Graeme Thorpe**From:** Brereton, Steven [Steven.Brereton@lancashire.gov.uk]**Sent:** 27 July 2012 17:20**To:** Graeme Thorpe**Cc:** Lorimer, Elliott; Kelsall, Kathryn (NE)**Subject:** Application Responses - 3/2012/0526

At the moment I am having to comment on an unprecedented number of renewable energy planning applications in the Forest of Bowland AONB. Consequently I cannot provide as detailed comments on landscape and visual impacts as I normally would do. The following then is a necessarily brief summary of the findings of my assessment of the applicant's submitted documentation and the likely landscape and visual impacts arising from the proposed wind turbine at Laneside Farm, Pendleton:

Plan 3 – Consented Wind Developments

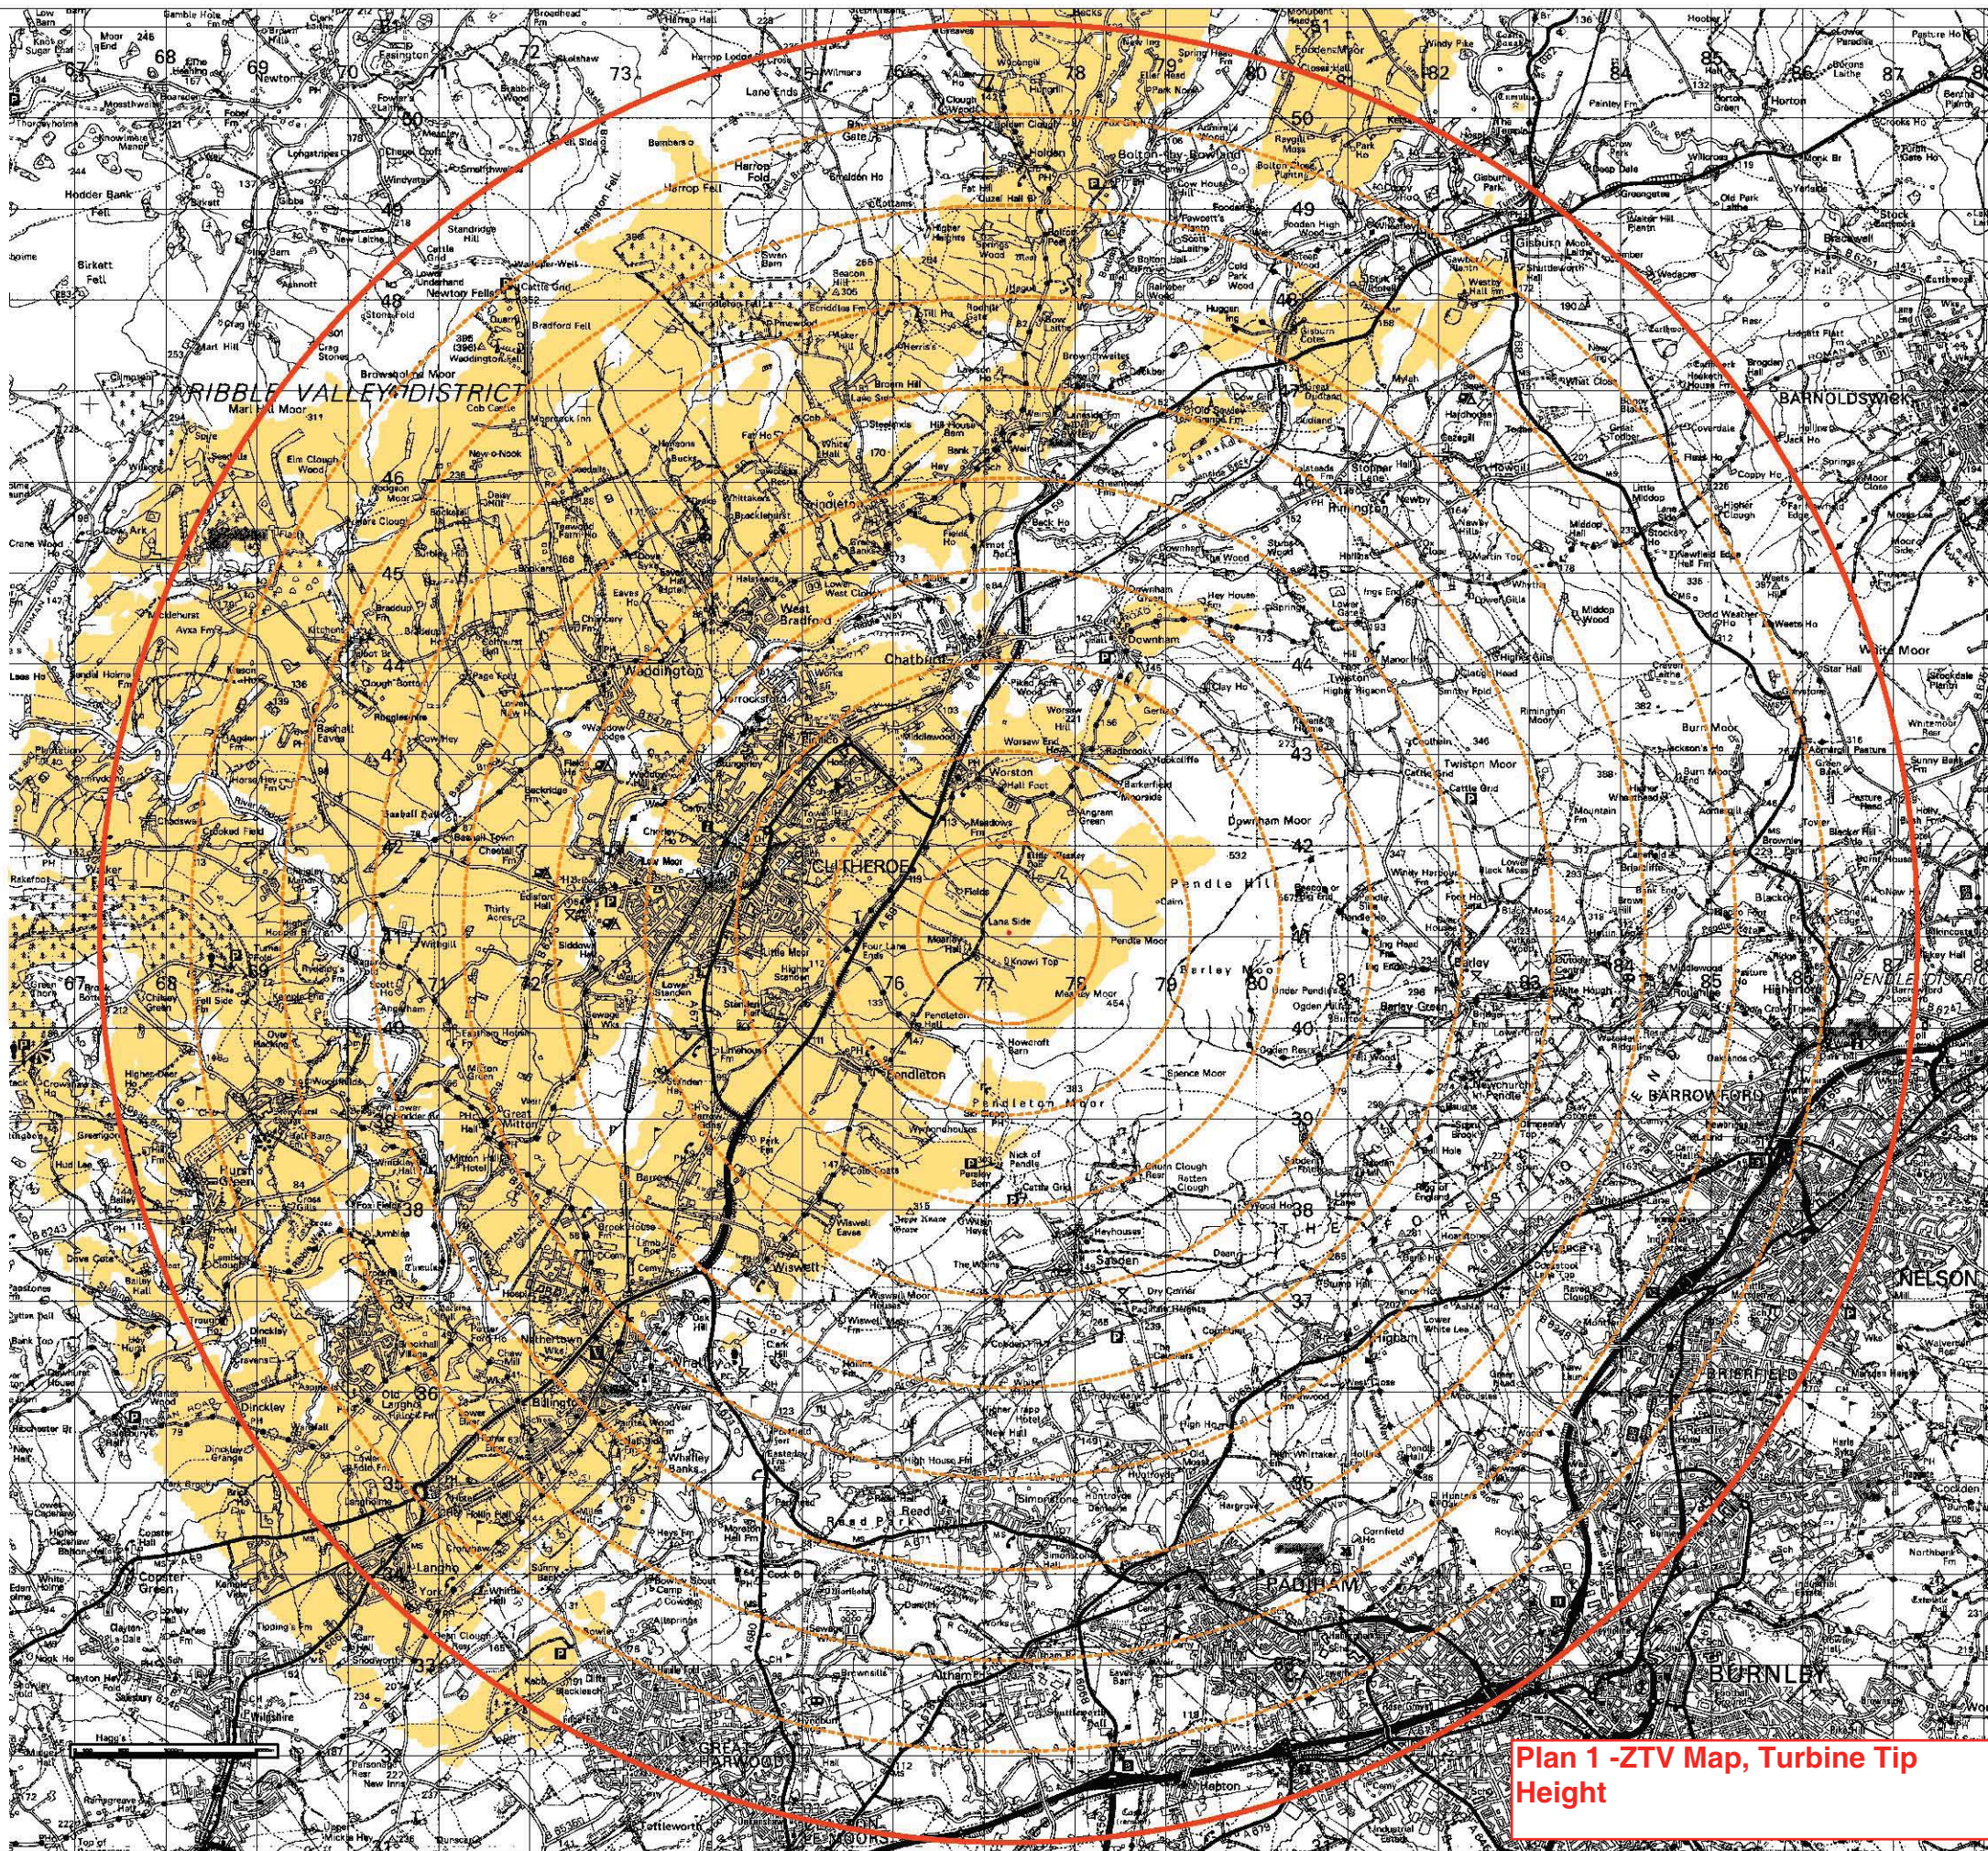
- There is no ZTV map showing cumulative impacts of the proposed wind turbine with other operational and consented wind energy developments. A useful map has been provided which shows the ZTV of the proposed turbine and the wind energy developments identified in Table 9, but this is no substitute for cumulative ZTV mapping. Consideration of cumulative impacts is important in determining the acceptability in landscape terms of the proposed wind turbine.
- The photograph used for the photomontage from viewpoint 2 is too blurred.

The absence of a cumulative impacts ZTV MAP is a particular concern as this key document helps to provide decision makers with a thorough understanding of the nature of likely landscape and visual effects. Consequently in the absence of this information I am unable to make a firm judgement on the cumulative impacts of the proposed wind turbine with other operational and consented wind energy development.

As highlighted above, the applicant has provided an incomplete assessment i.e. no ZTV mapping, of the proposed wind turbine's cumulative impacts with consented and operational wind energy development. In the absence of this key information, I cannot undertake a full assessment of likely cumulative impacts or make final judgements on the acceptability of the scheme proposals in landscape terms. Even though cumulative ZTV mapping has not been provided, as evidenced by my comments above, it does seem highly likely that my final judgement on acceptability of landscape and visual impacts will not be a positive and supportive one.

I recommend that the applicant provides cumulative ZTV mapping so that I can complete my assessment of landscape and visual impacts.
